**From:** Martyn White [REDACTED]  
**Sent:** 24 December 2019 10:03  
**To:** Planning.Responses [REDACTED]  
**Cc:** Finlay Gardner [REDACTED]  
**Subject:** AB/94/19/HH & AB/95/19/L

#### **AB/94/19/HH & AB/95/19/L**

No 30 High Street is a Grade 2 Listed Building and forms part of an imposing group comprising 30-34 High Street which terminate the sequence of street fronted historic commercial/retail buildings on the east side of High Street. The mid-18th Century facade of the group is of particular importance with its attractively bold brick detailing and fenestration

Ground Floor Plan 1:100

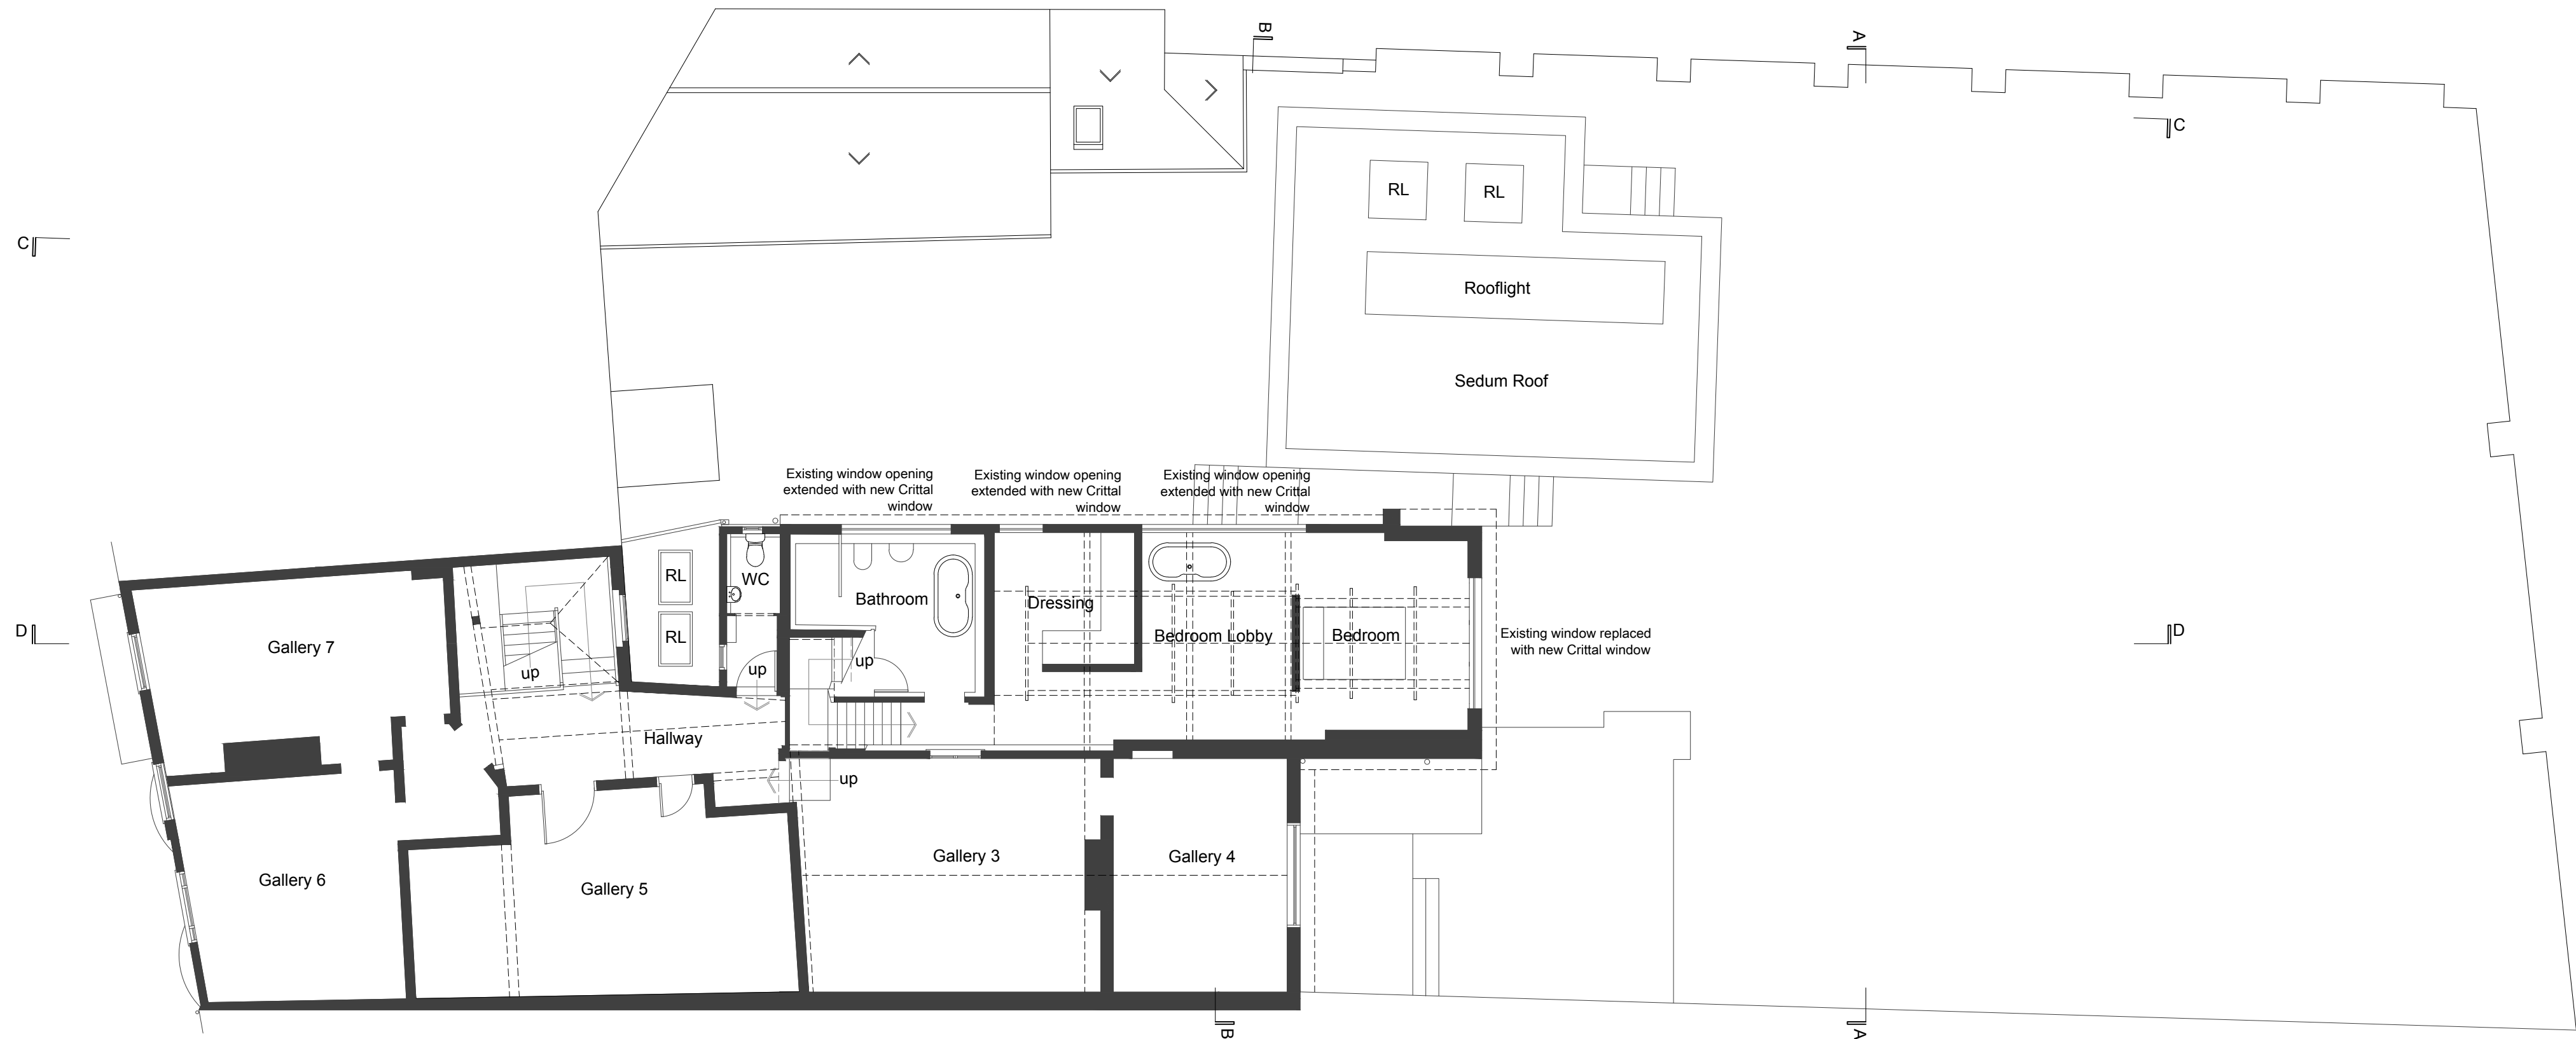
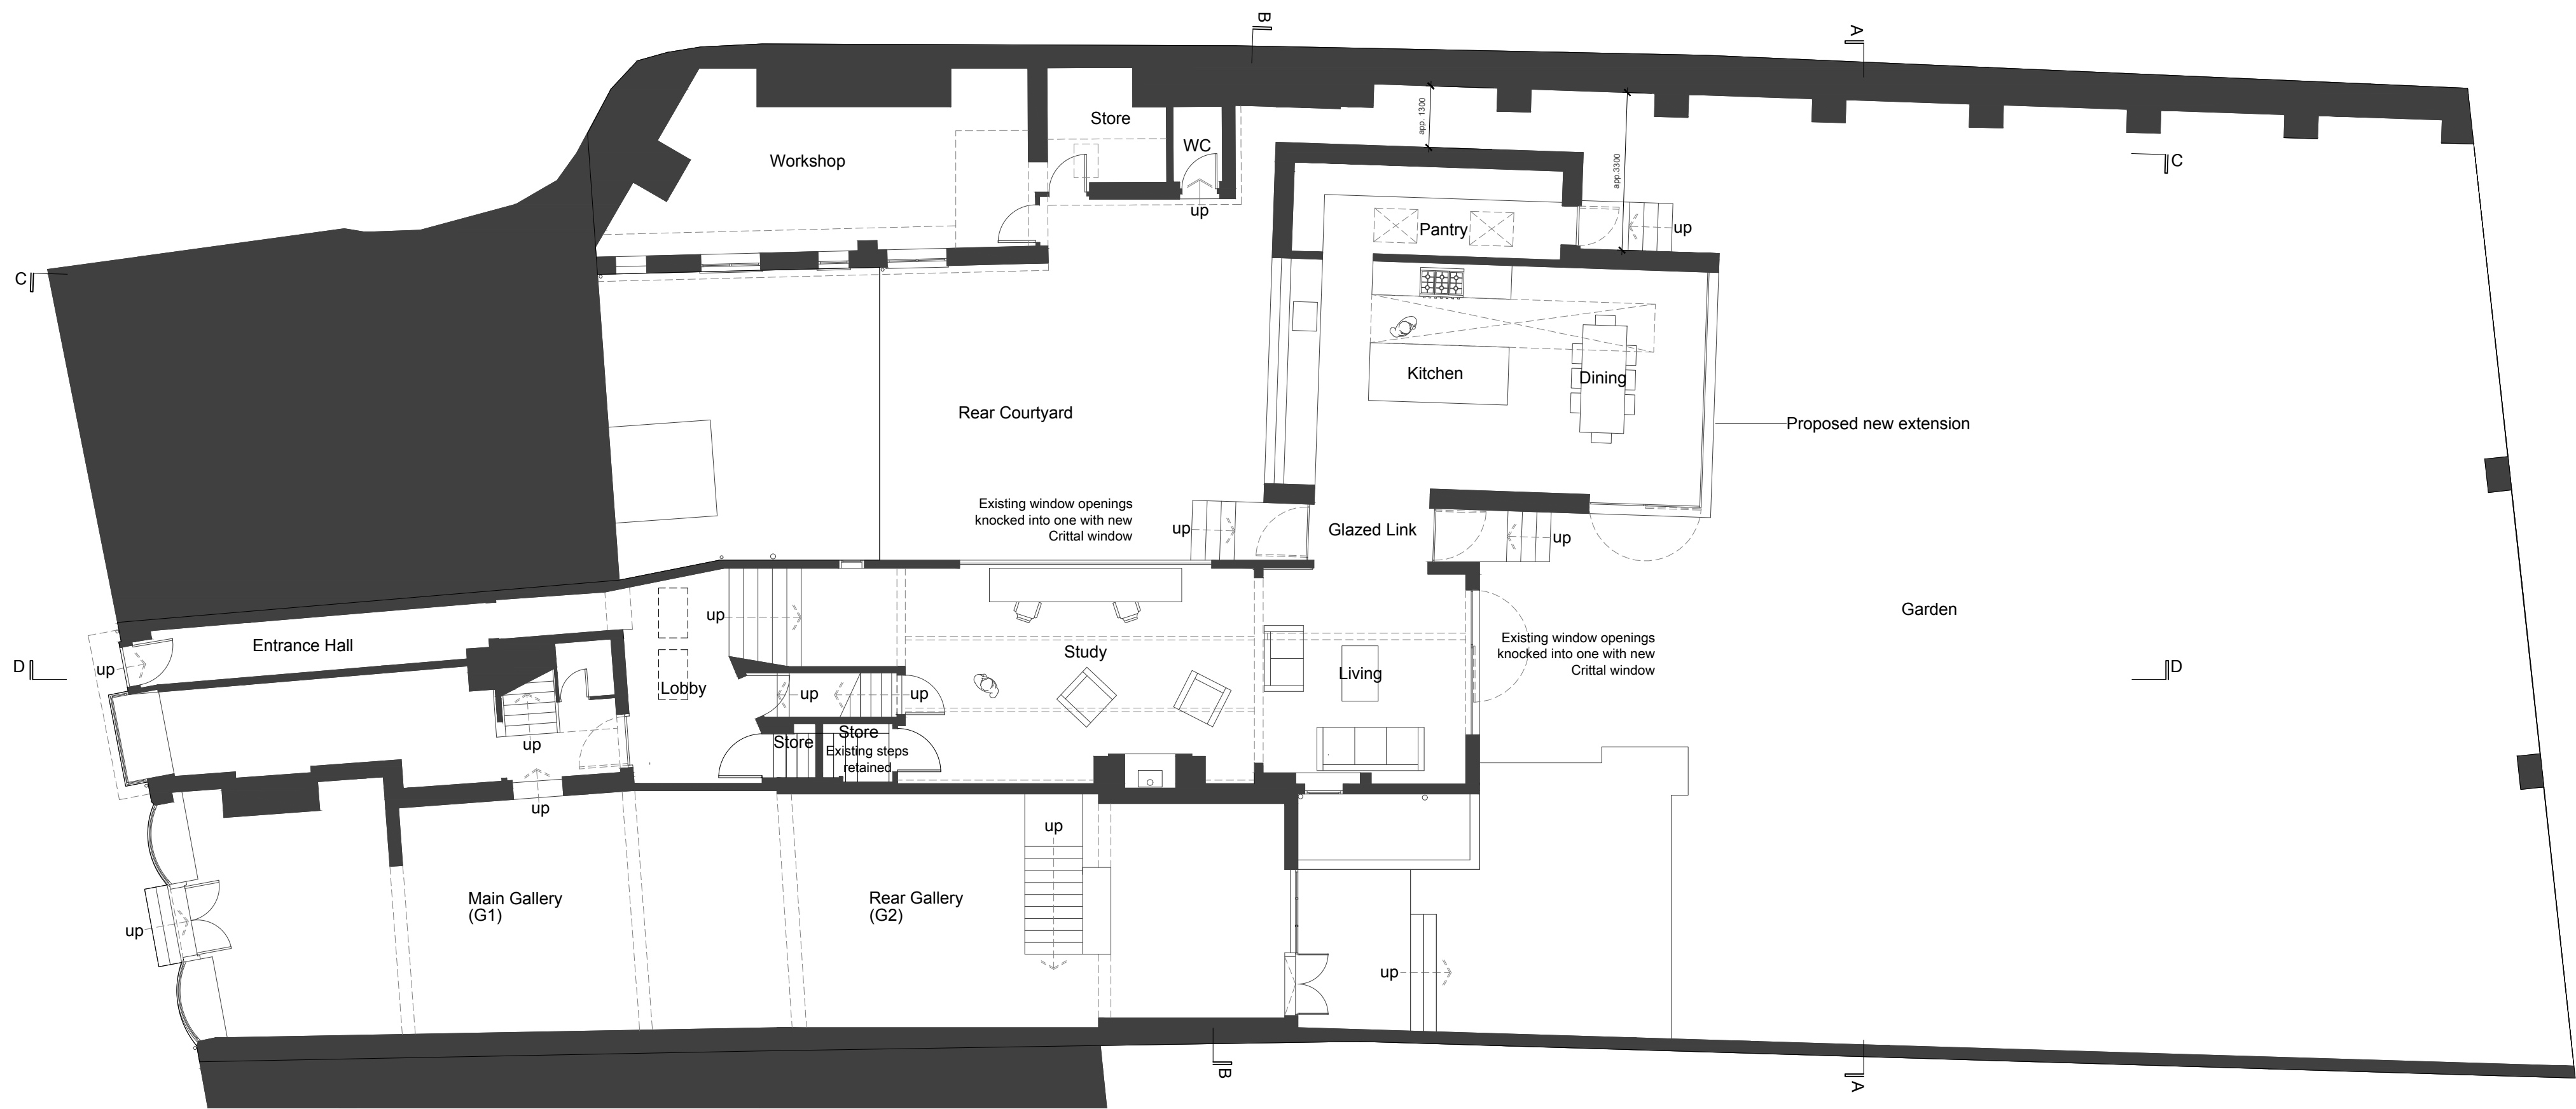
The intention is also to open up the 'main room' and the kitchen to create a new study and living room area, and therefore create a larger, more usable space. It is positive to see the retention of two 'nib' areas to ensure that the former division can still be understood. It also results in a limited amount of historic fabric being removed.

If you are minded to approve the applications it is suggested that conditions be attached requiring the submission of **precise** details of materials, finishes and fenestration. Samples of materials should be provided, along with details of the proposed brick bond. Details of any internal joinery should also be required, including any skirting etc. Sample panels could also be provided where necessary.
